Timberline Storage Yard, PPR-19-042

Please accept the following comments from El Paso County Public Health (EPCPH) regarding the project referenced above:

**FULL SPECTRUM DETENTION POND OUTFALL**  
NOT TO SCALE

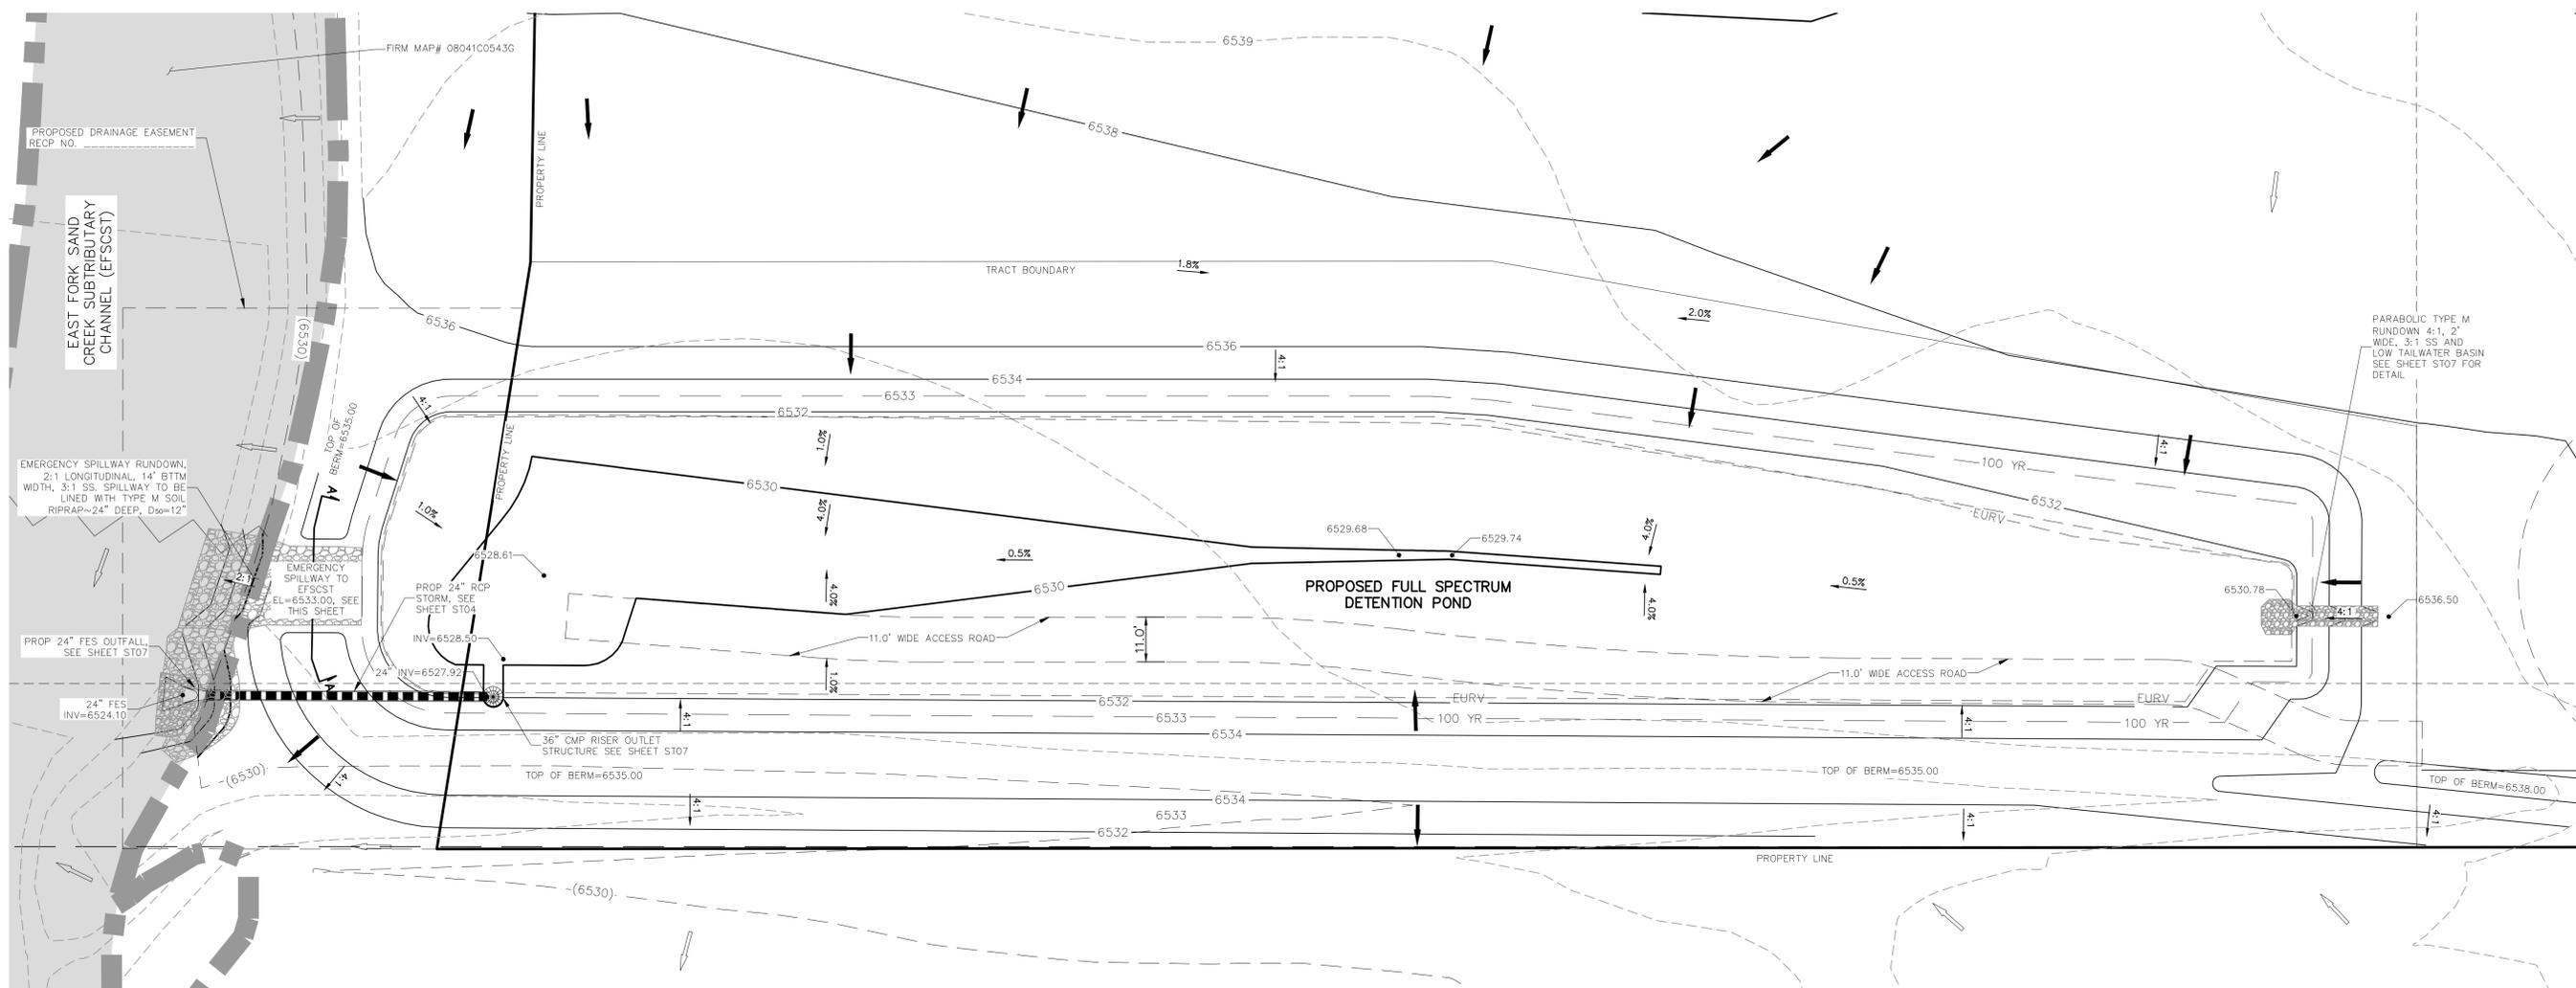
- **Cherokee Metropolitan District is currently providing water and wastewater services.**
- **The water quality detention basin must have mosquito control responsibilities included as a part of the construction design and maintenance plan to help control mosquito breeding habitat and minimize the potential for West Nile Virus.**
